CITY OF ALBUQUERQUE

June 21, 2018

RE: **FedEx Fuel Station**
Daytona Rd NW
Grading Plan Stamp Date: 5/29/18
Hydrology File: K09D026C

<b>FEDEX GROUND</b> <b>ALBUQUERQUE, NM</b>	DRAWN BY LA
	<b>OVERALL GRADING</b> <b>AND DRAINAGE PLAN</b>	DATE 05/22/2018
	<b>TERRA WEST, LLC</b> 5571 MIDWAY PARK PLACE NE ALBUQUERQUE, NM 87109 (505) 856-3100 www.tierrawestllc.com	2018025-BASE-GR
	SHEET # <b>C-2</b>	JOB # 2018025

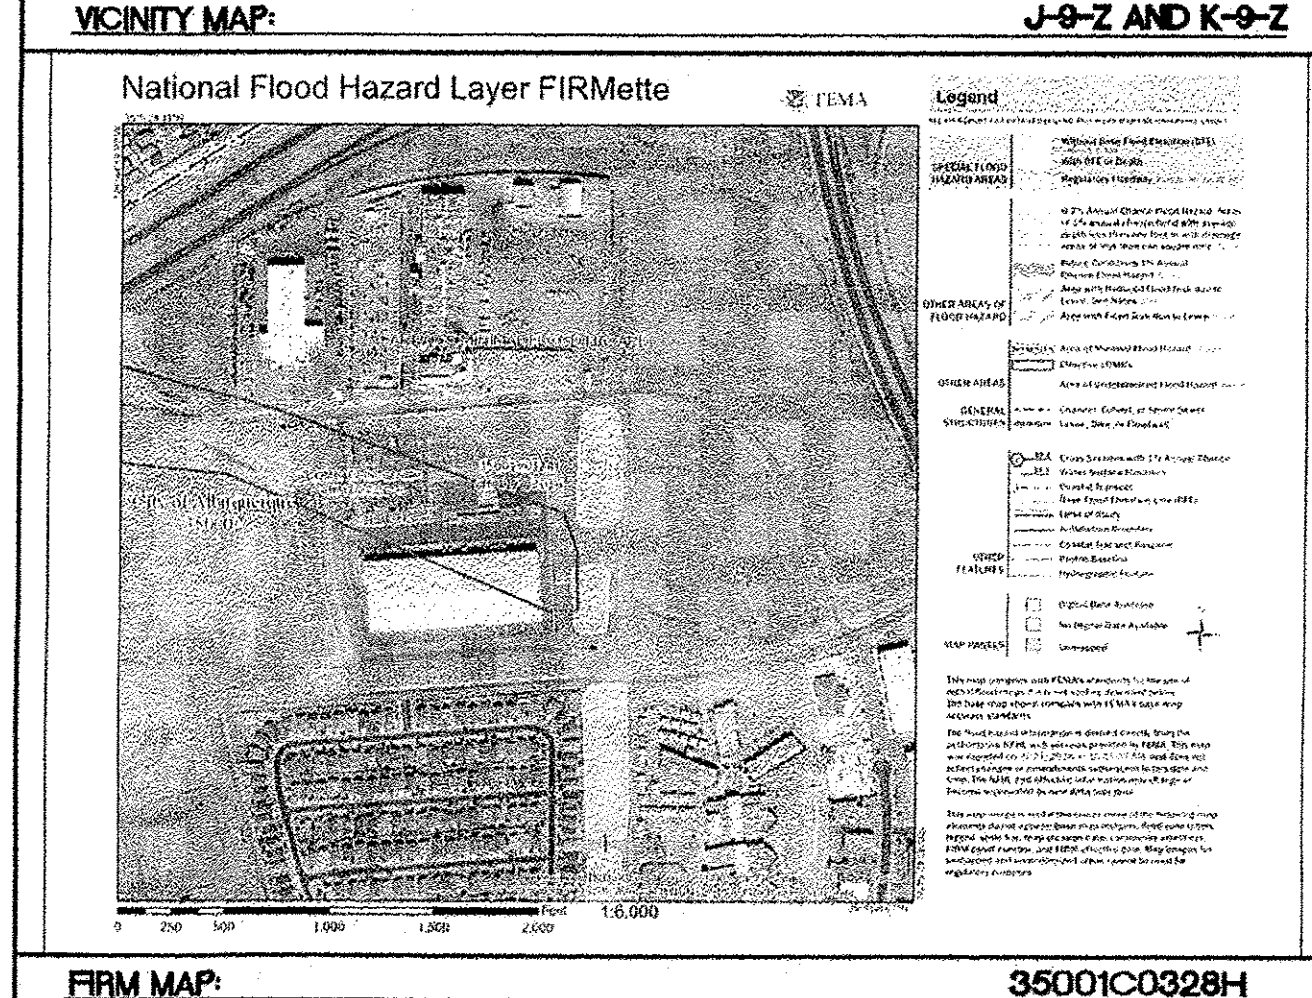
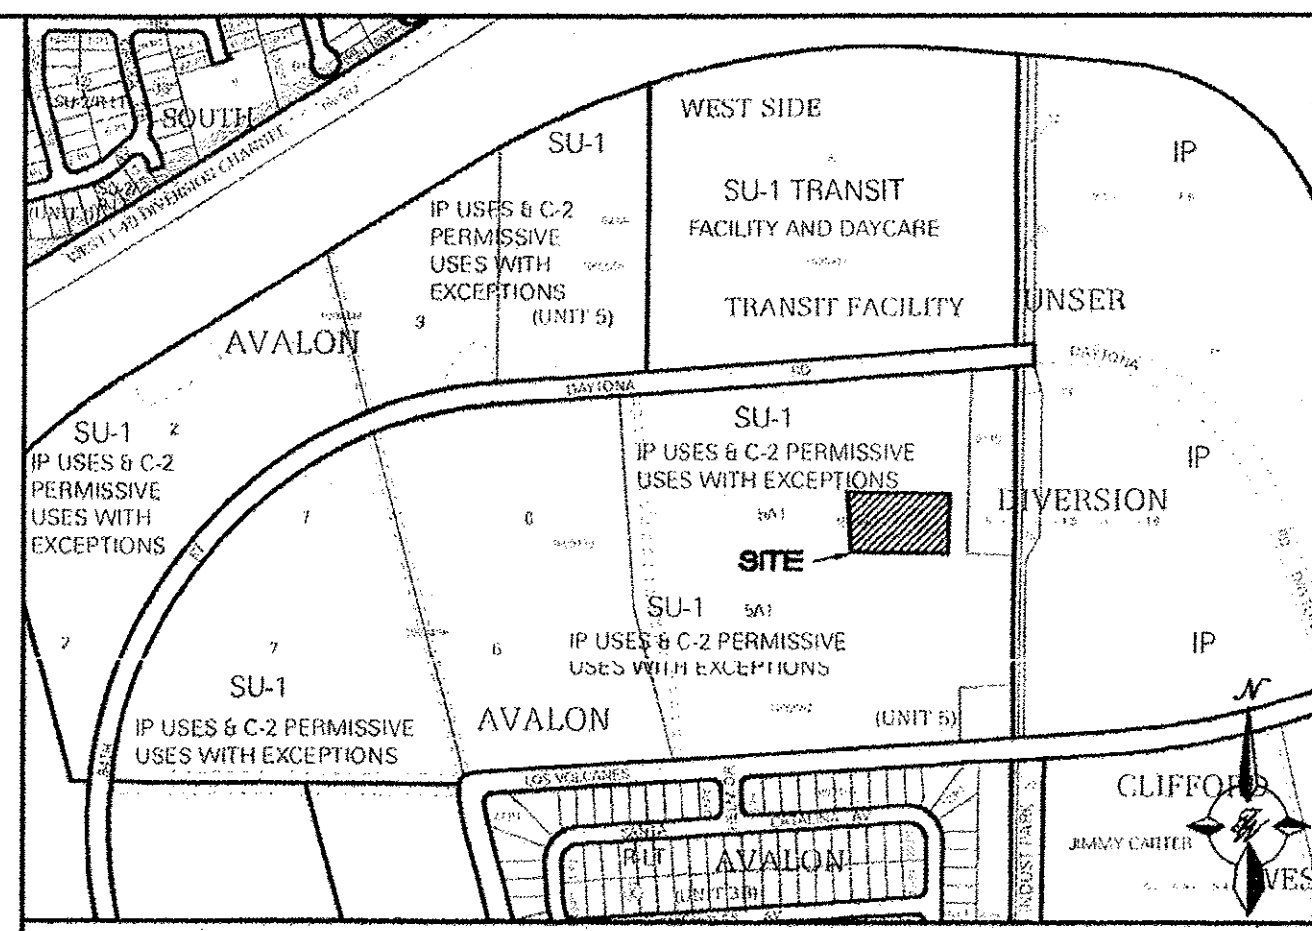
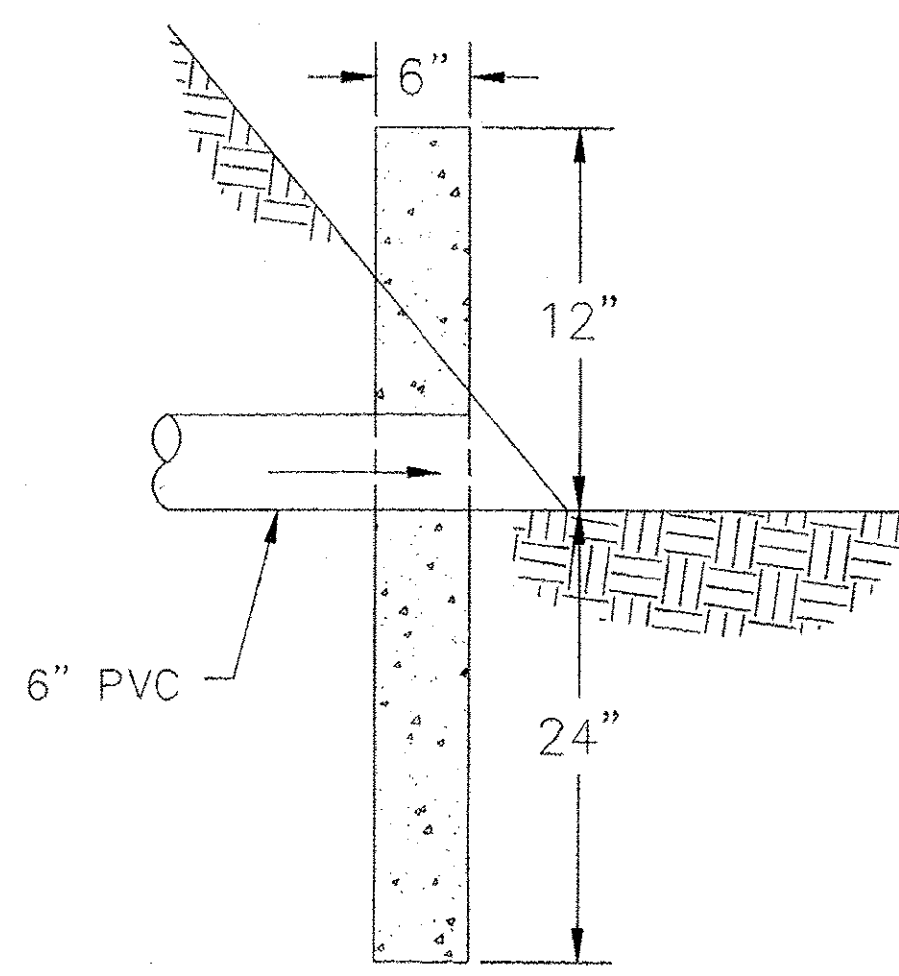
1. Include discussion of how the first flush is being retained on-site. Provide supporting calculations, drainage basin exhibits, etc demonstrating that the area of new impervious (and redeveloped impervious, if any) will be routed to an adequately sized first flush facility.

2. The proposed contours do not tie-in to existing along the edges of the project limits and appear to be drawn incorrectly. Increase the density of existing and proposed contour labeling and include minor labels.

3. The spot elevations do not agree with the contours; it is unclear if they are existing or proposed. Please differentiate the labels to specify and confirm they agree with the contour data.

ENGINEER'S SEAL  RONALD R. BOHANNAN P.E. #7868	FEDEX GROUND ALBUQUERQUE, NM DETAIL GRADING PLAN	DRAWN BY LA
		DATE 7/5/2018
 TIERRA WEST, LLC 5571 MIDWAY PARK PLACE NE ALBUQUERQUE, NM 87109 (505) 858-3100 www.tierrawestllc.com	2018025-BASE-GR	SHEET # C-2A
		JOB # 2018025

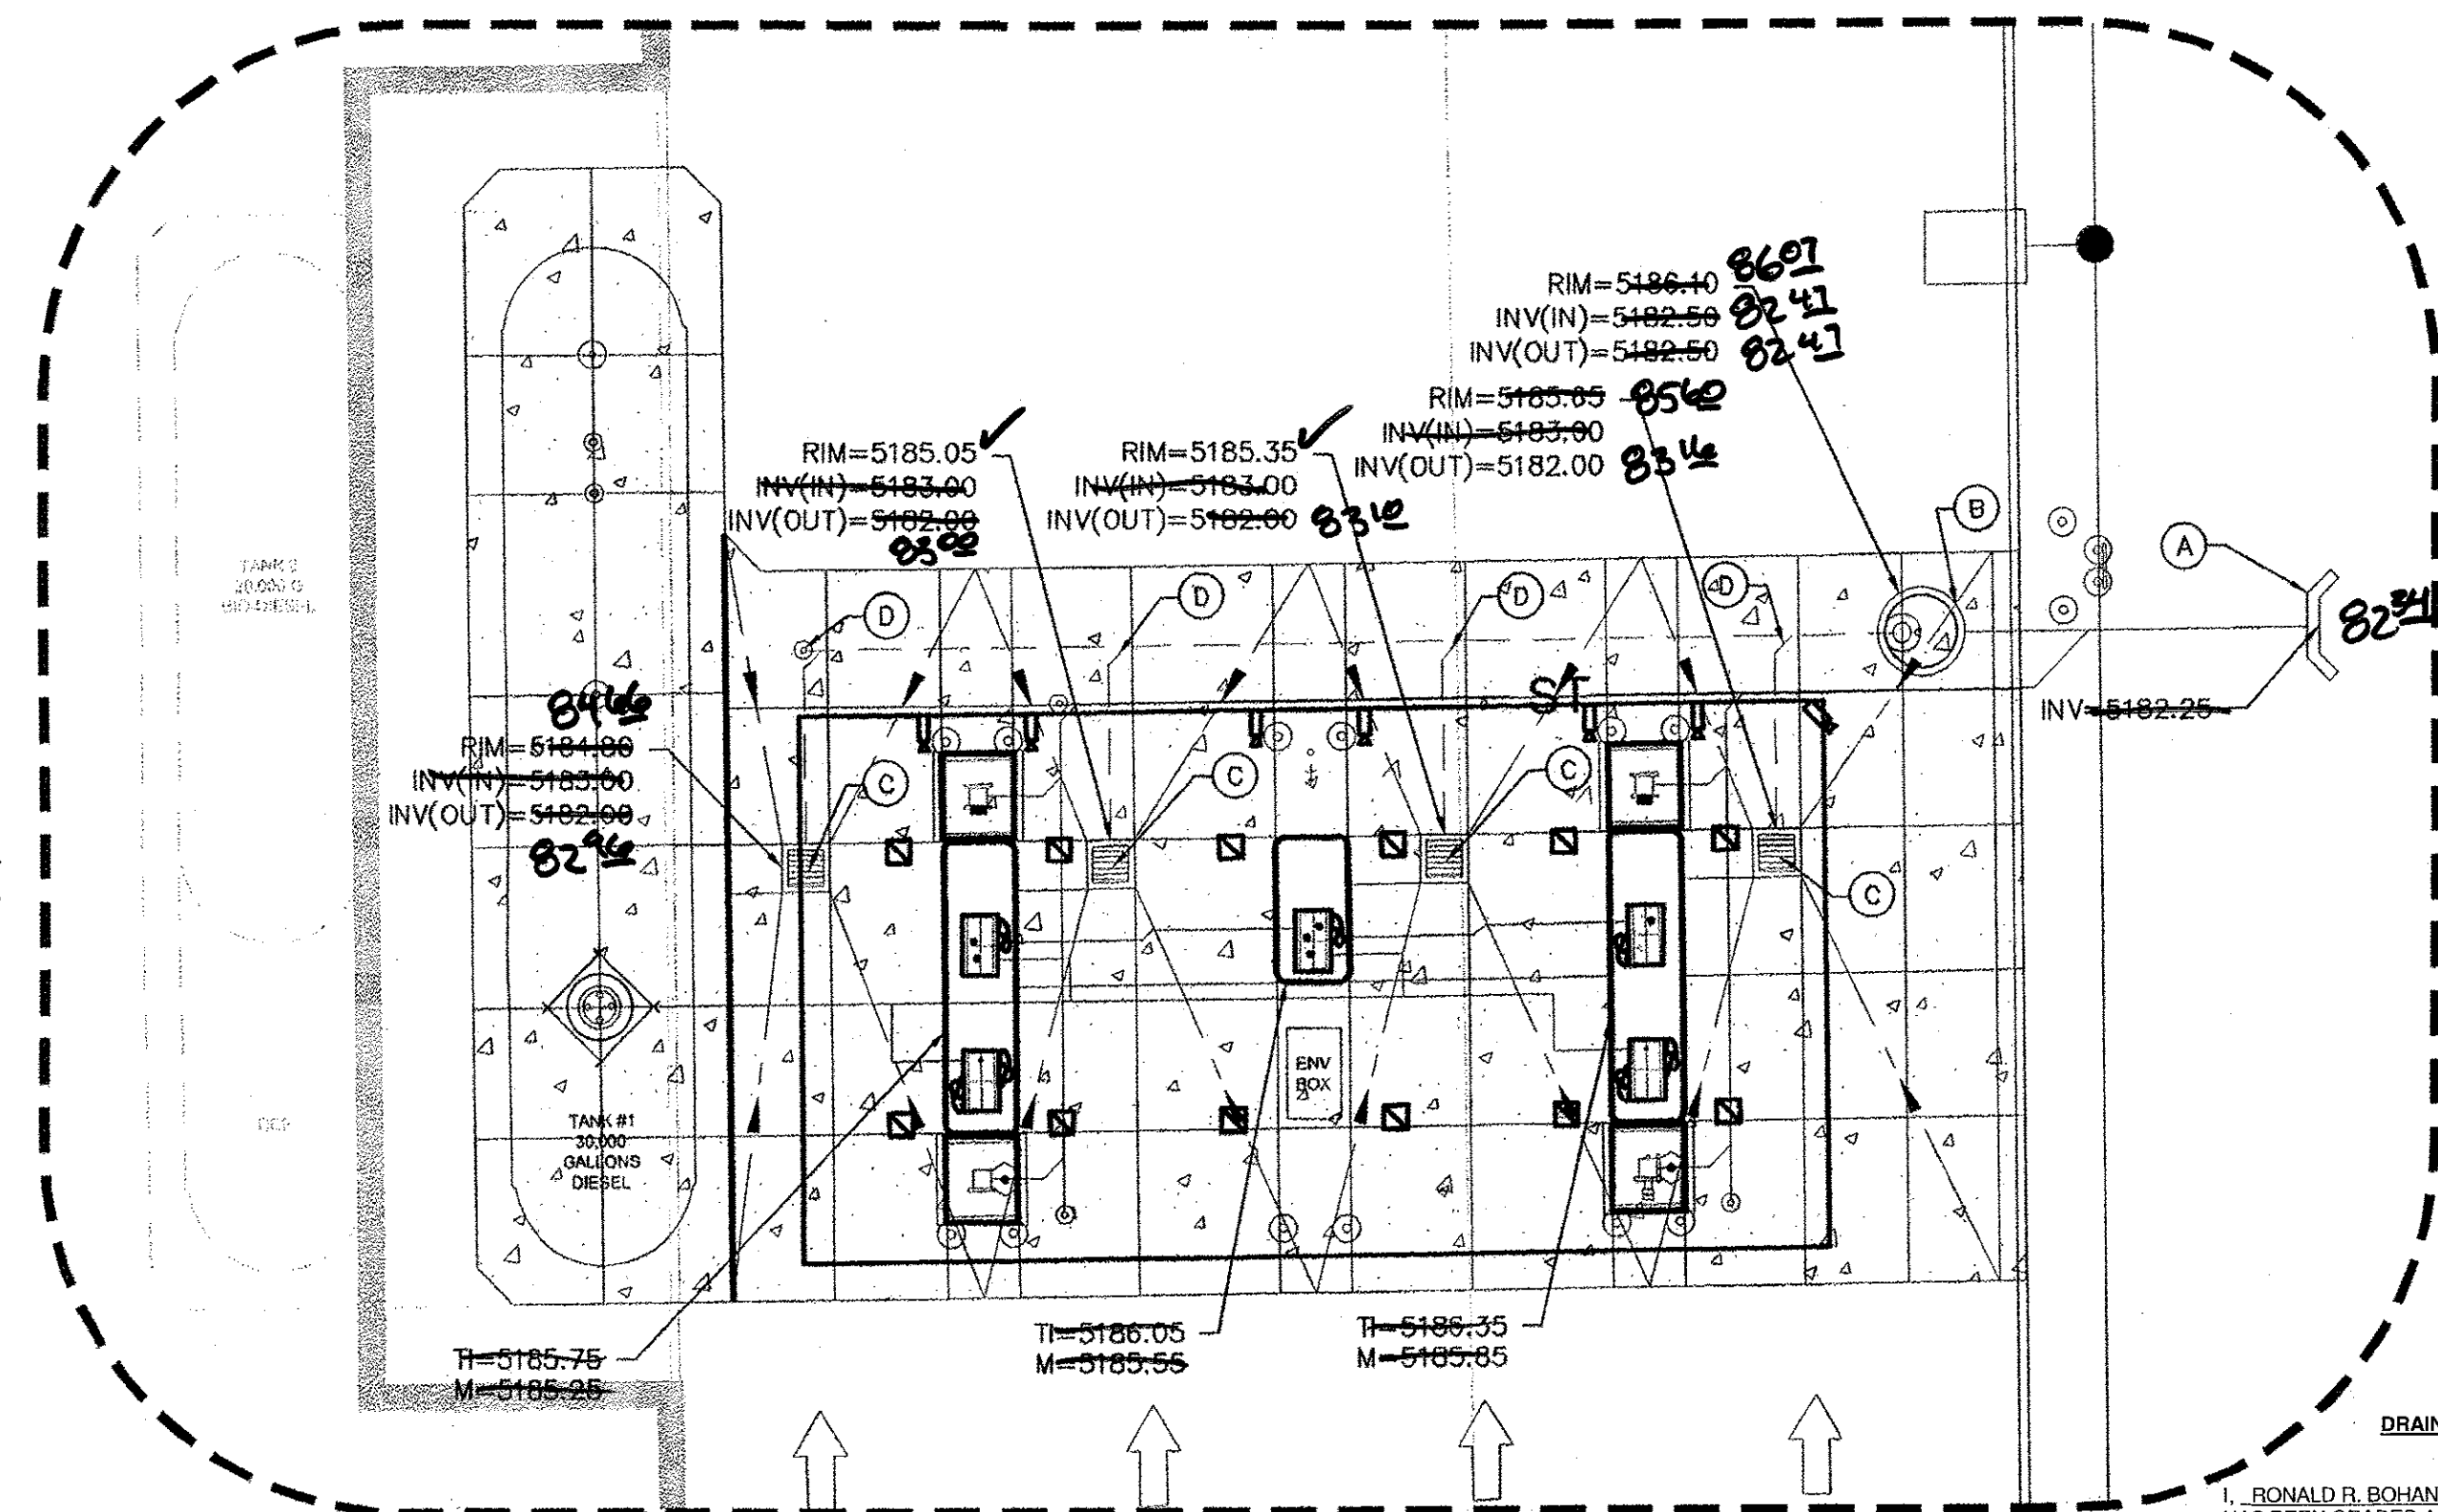
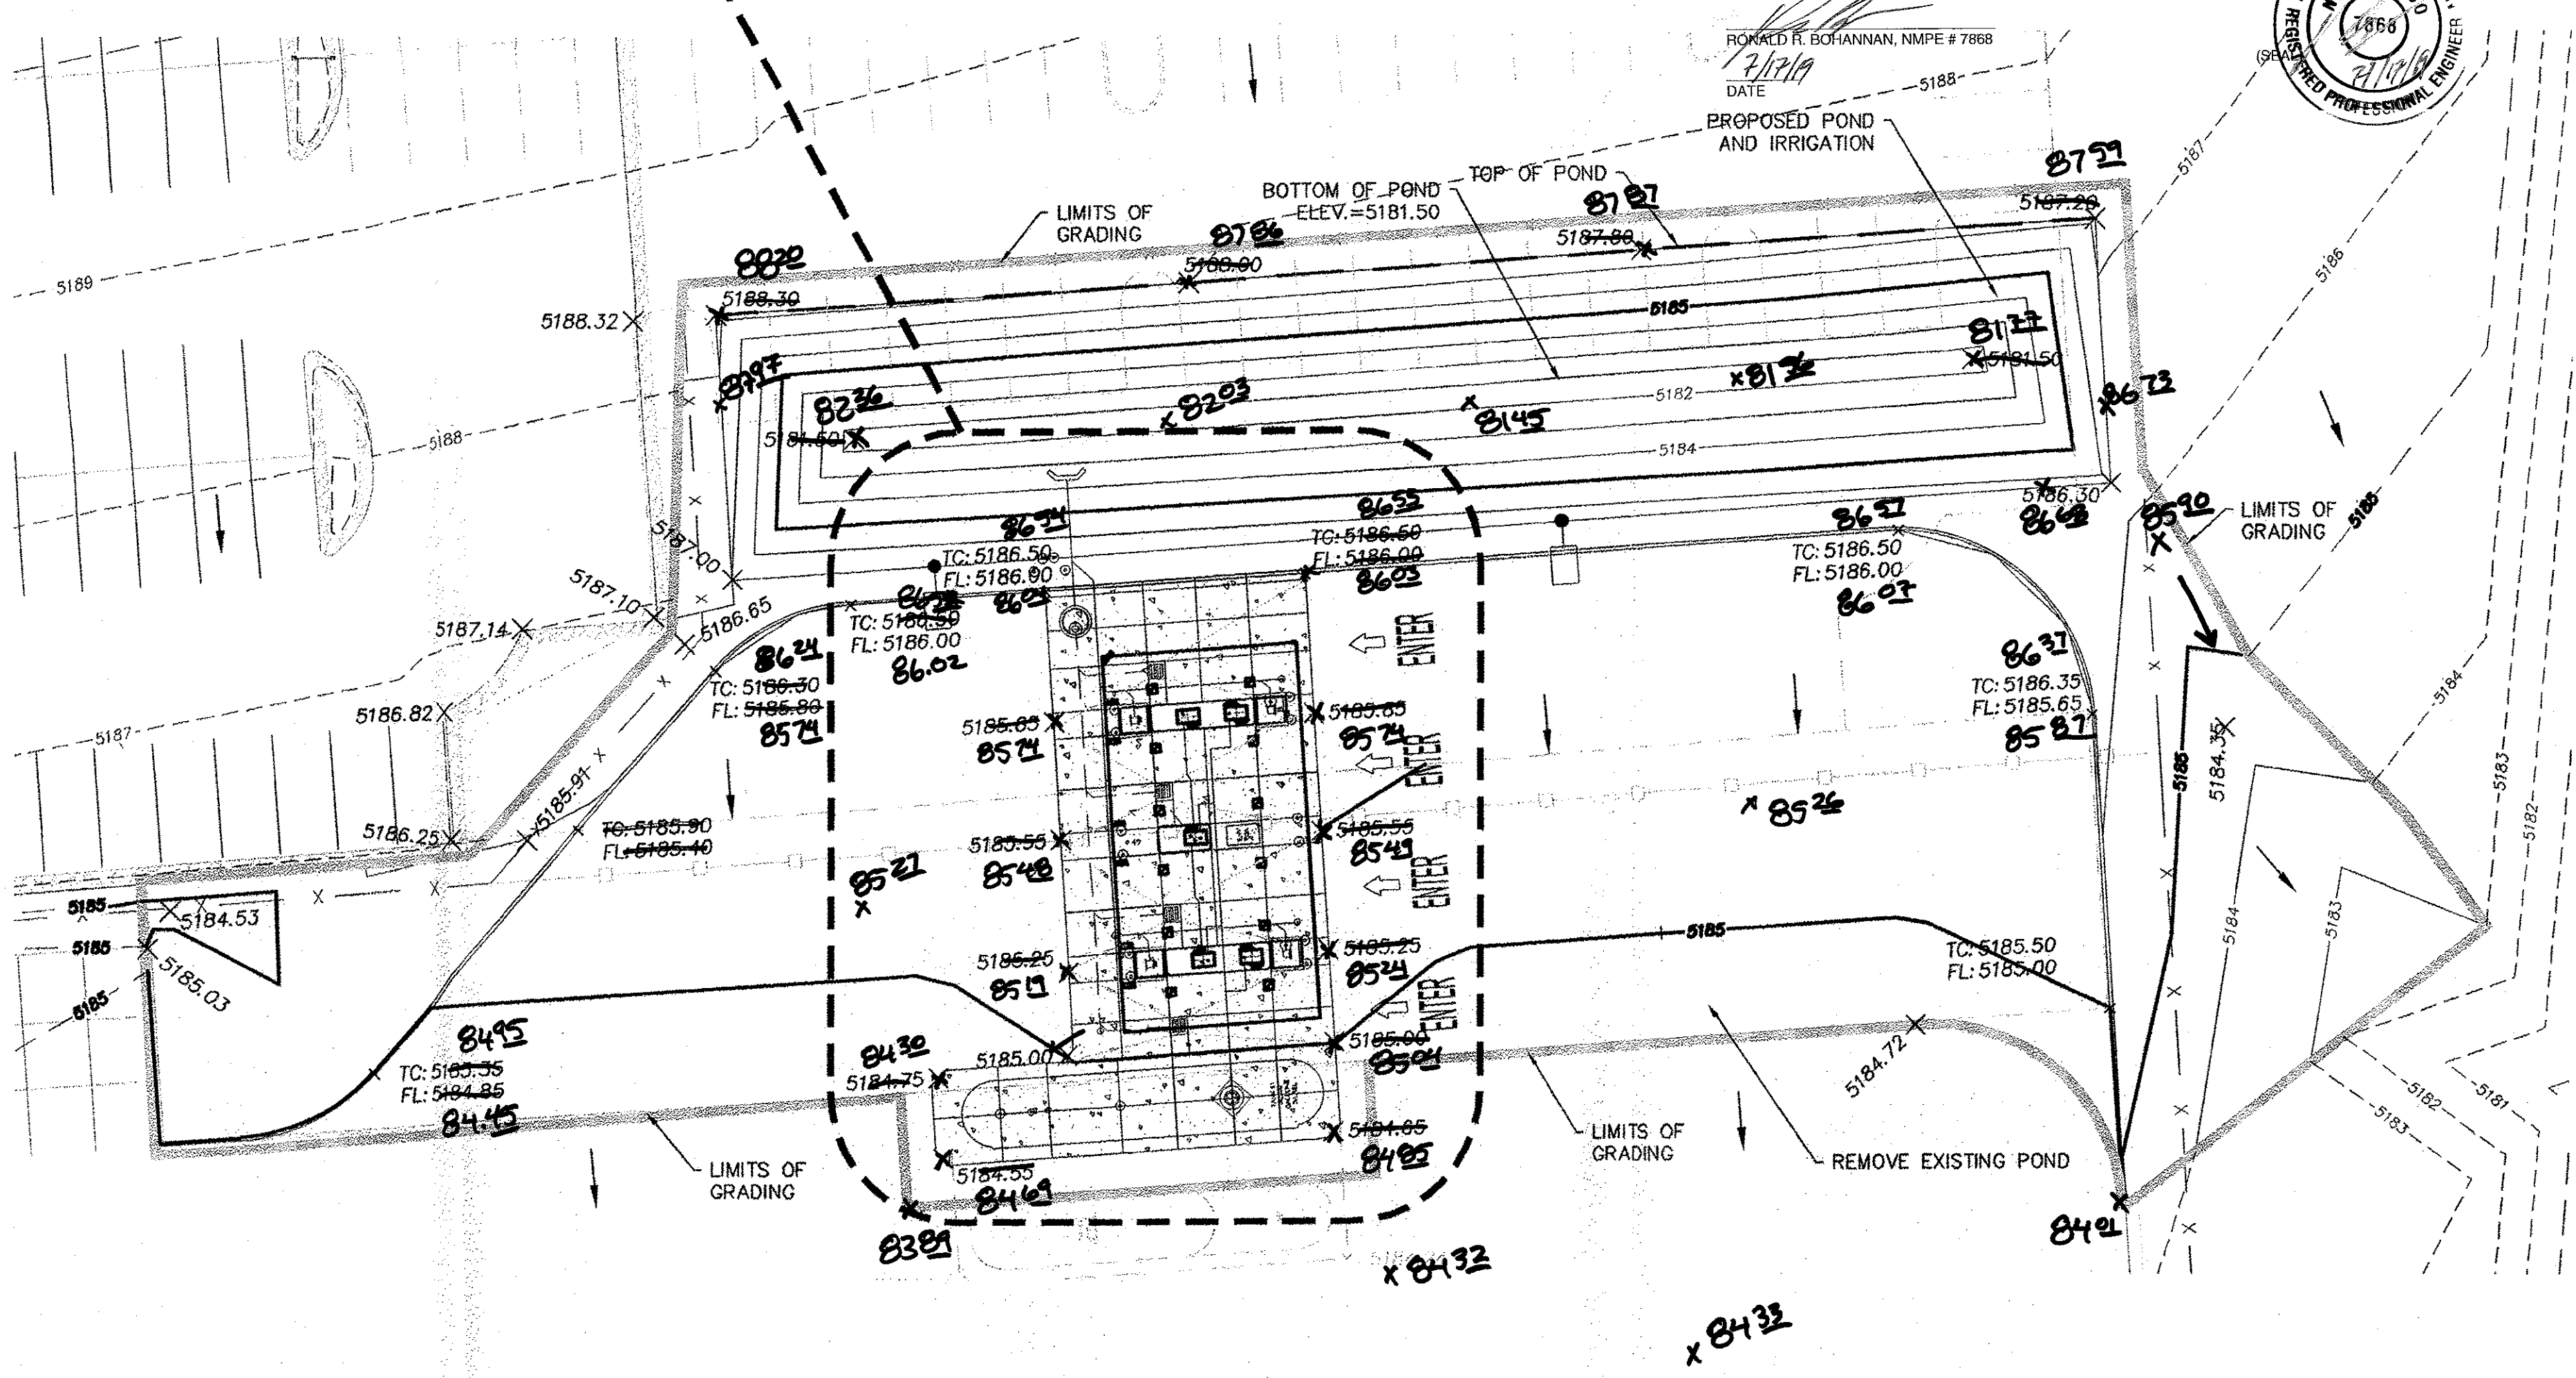
4. For fueling stations, demonstrate *control of oil from vehicle parking areas* per DPM Chapter 22.9.E, Table 1. The storm interceptor noted on sheet GR-2 appears to be intended for this, but it needs show that the parking area (around the fuel islands) is contained and drains to it. Please provide a specification for the storm interceptor and area inlets (notes B and C) as well.

5. The excavation and repaving for the UST should be included in the limits of work/grading.
6. For Information. Based on the information provided in this plan, Hydrology does not anticipate that public drainage infrastructure will be required. However an approved
